INDEPENDENT EXPERT REVIEW

WHITE ROCK WIND FARM PROPOSAL

*Prepared for
NSW DEPARTMENT OF PLANNING
& ENVIRONMENT*

17th July 2019
REF: 990-Z1-01
REVISION: D

Figure 1 WRF Stage 2 Obstacle lighting layout plan

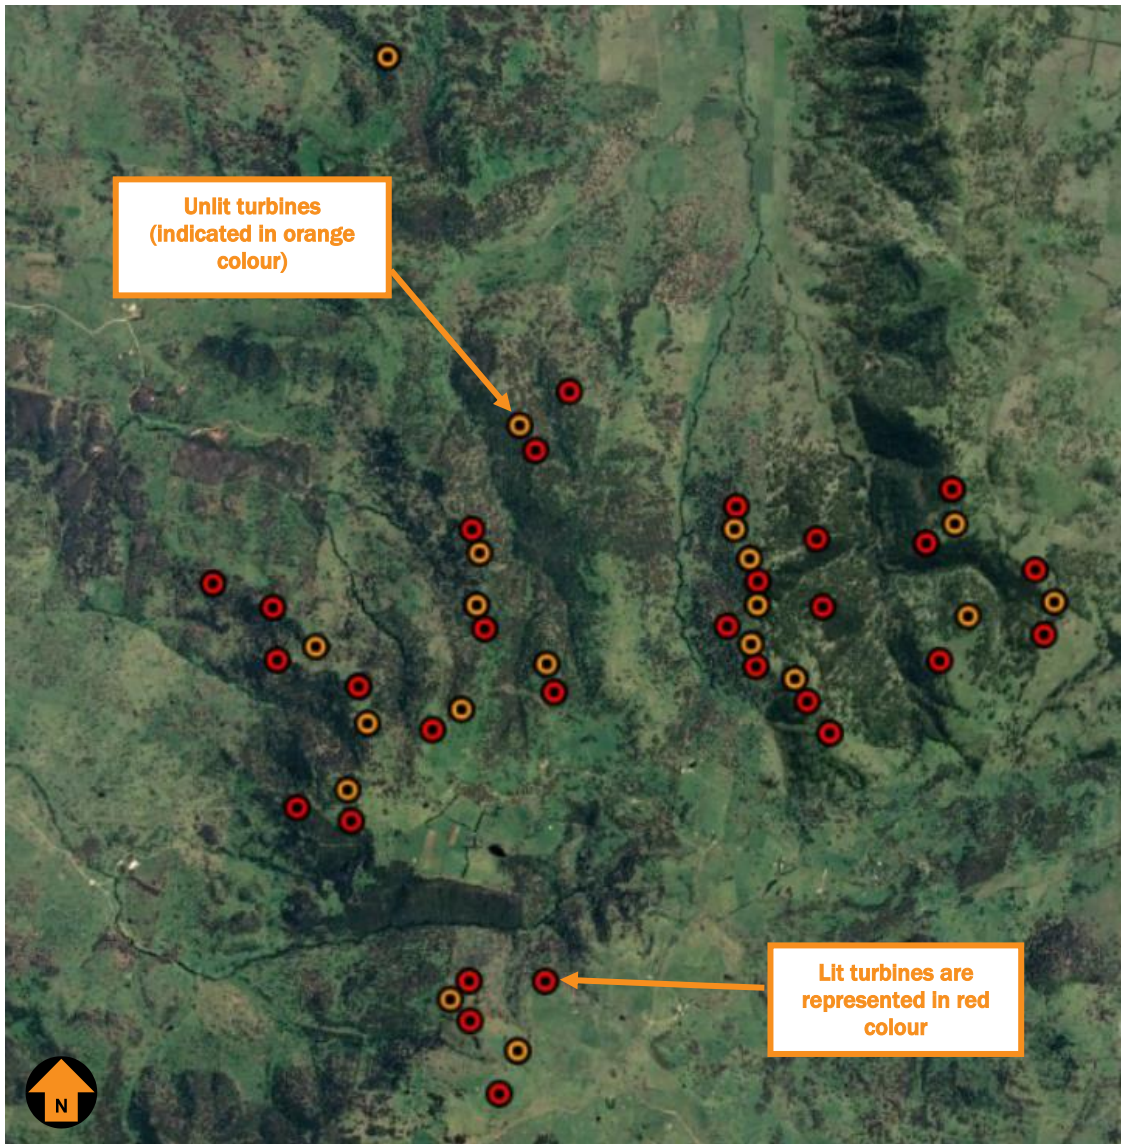
The WRWF Night Lighting Assessment of July 2018 notes that subsequent to preparation of the Mod 6 VIA and as a result of the increased maximum tip height of the WRWF Mod 6 to 200m, the Civil Aviation Authority (CASA) have recommended that AHL be installed to operate at night and times of reduced visibility. The performance requirements for the AHL are set by CASA and the determination of impacts is identified in the VAB.

In reviewing these requirements, the Proponent's Night Lighting Assessment (NLA) discusses Australian Standard AS 4282-1997 including the definition of both obtrusive lighting and spill lighting, coming to a conclusion in Section 4 that the ability of AHL to be assessed against AS 4282 performance requirements is very limited. The intent of AS 4282 and the VAB are both to manage obtrusive light. AS 4282 notes that spill lighting is obtrusive if, because of directional or spectral attributes in a given context, it gives rise to annoyance, discomfort or distraction. The WRWF night lighting environment is a context of highly identifiable lighting placed into a dark sky with few other night light sources. In Section 8 of the NLA the final paragraph then concedes that

thereby identifying the AHL light as obtrusive as defined in AS 4282. We consider that the lighting should therefore be assessed against the performance requirements of AS 4282.

The second conclusion reached in the NLA Section 10 that impacts on residential dwellings will be Moderate is appears overly simplistic and does not constitute an assessment of the actual visual impacts. It is our opinion that from individual residences the impacts will vary greatly depending on the aspect, number of lit turbines and the distance of the turbine from the viewer. Aviation Projects Pty Ltd has now prepared an obstacle lighting layout plan indicating the turbines to be lit if AHL is required. Using that as a base and using the visual parameters outlined above, we have assessed the residences individually in **Section 3** of our report.

Overall, it is our opinion that the addition of AHL in any form would significantly increase the visual impacts of the Project and that even limited AHL would significantly increase the impact levels assessed in the context of an unlit project as described in the tables in **Section 3** of our report.

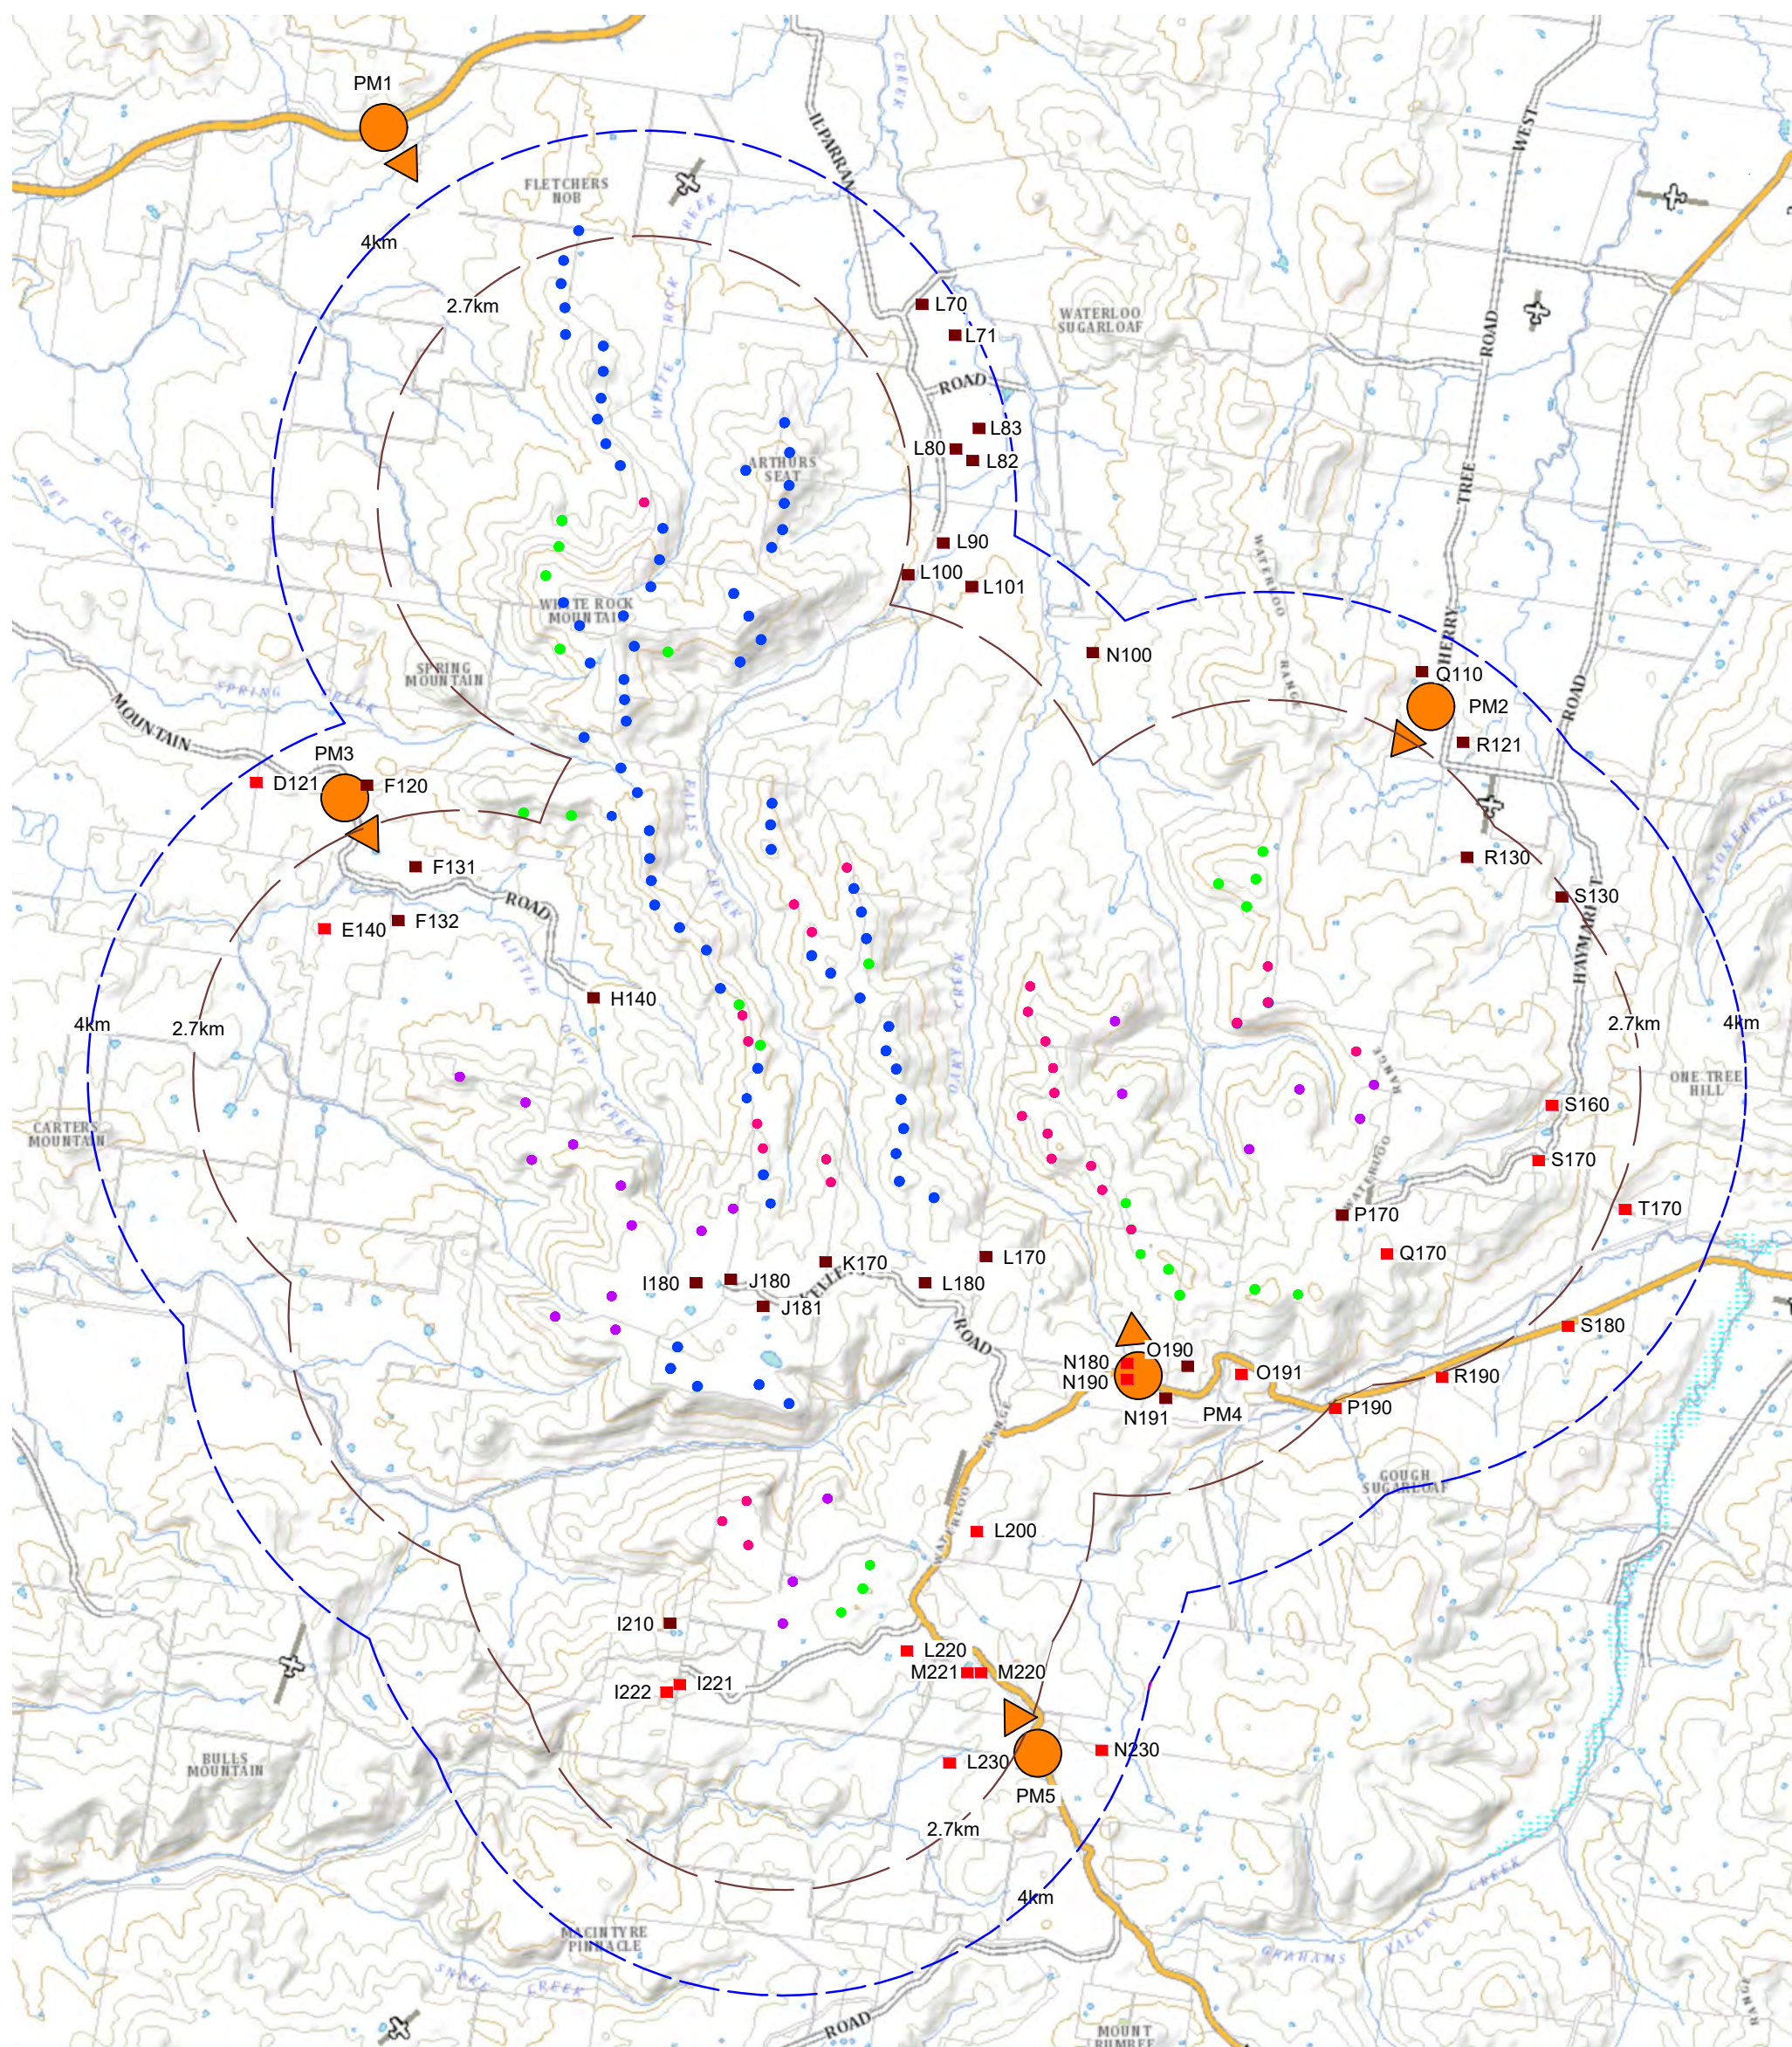
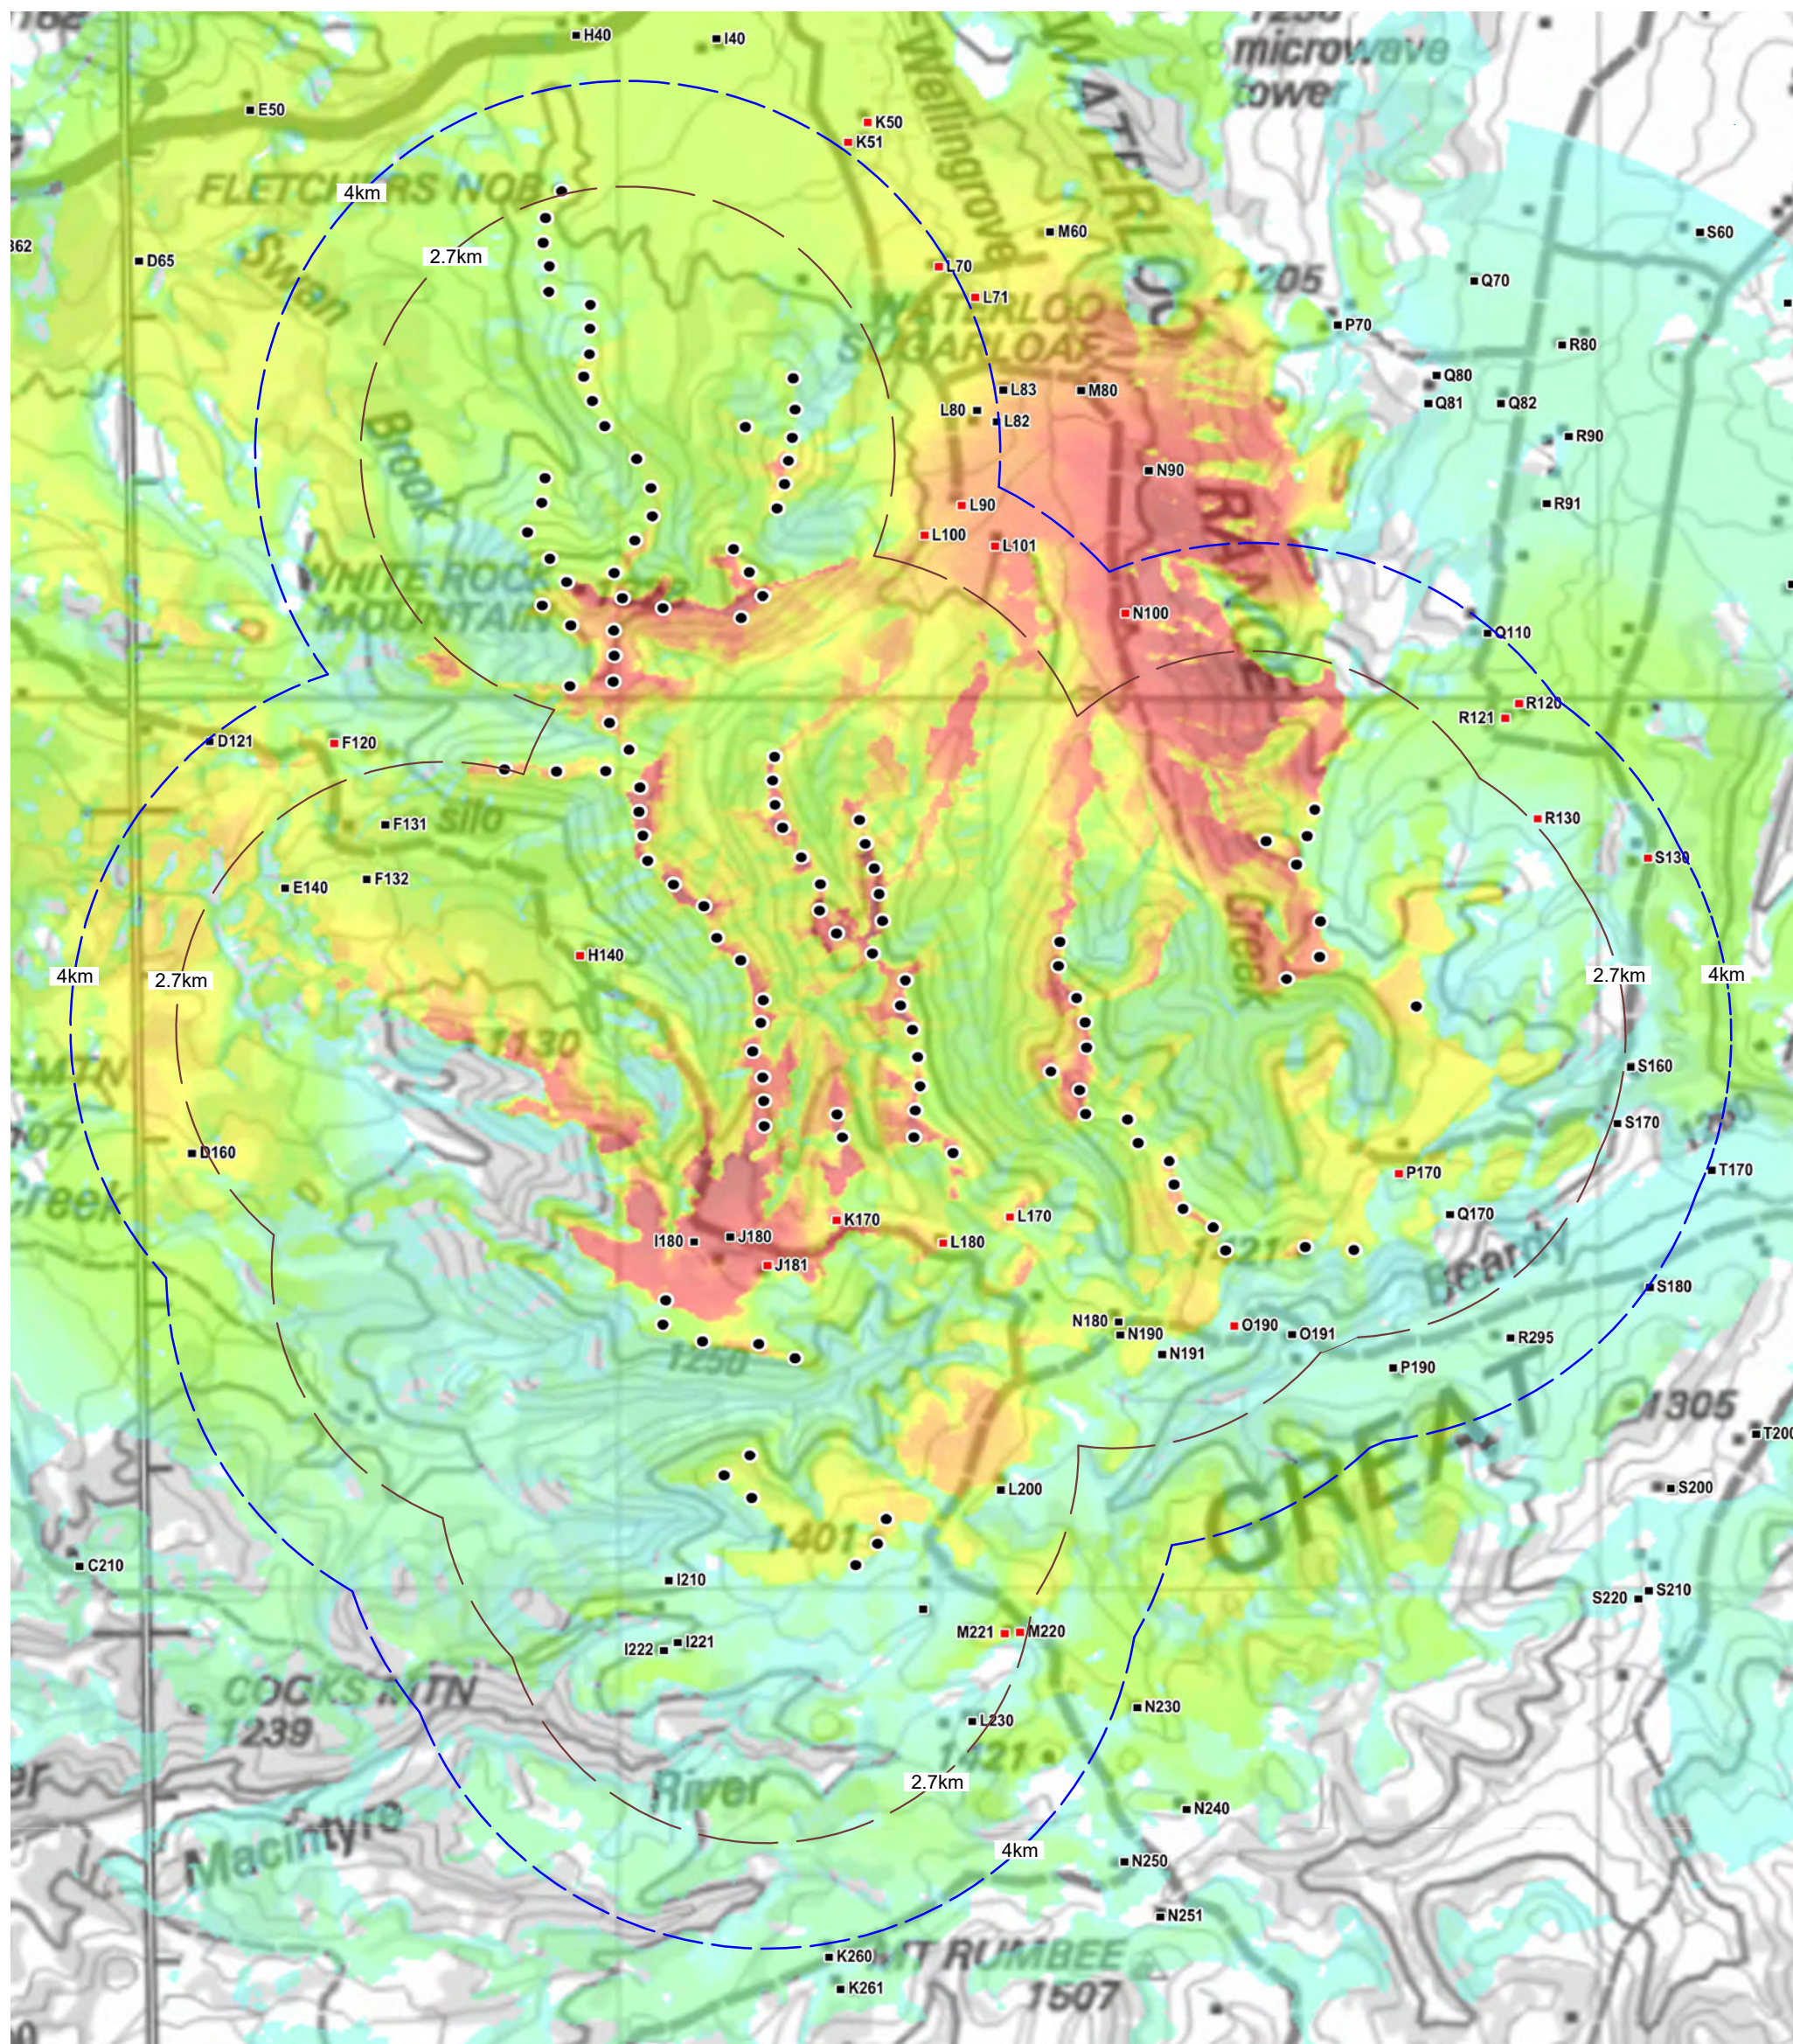
It should be noted that this statement only refers to any "additional significant cumulative visual effects". This is not a measure of the complete cumulative impact of the project and any surrounding projects. This statement also makes no allowance for any rating of cumulative impacts for individual residences. As the previous the 2012 Approval LVIA also makes no attempt to quantify cumulative impacts, there seems to be no data to act as a baseline from which this statement can be validated.

The VAB clearly indicates and describes the correct use of the multiple wind farm tool as a key step in assessing the overall visual impacts of a wind farm and the omission of this step in the LVIA results in no preparation of sector analysis or angle of view analysis that would provide an analytical basis upon which to base a conclusion.
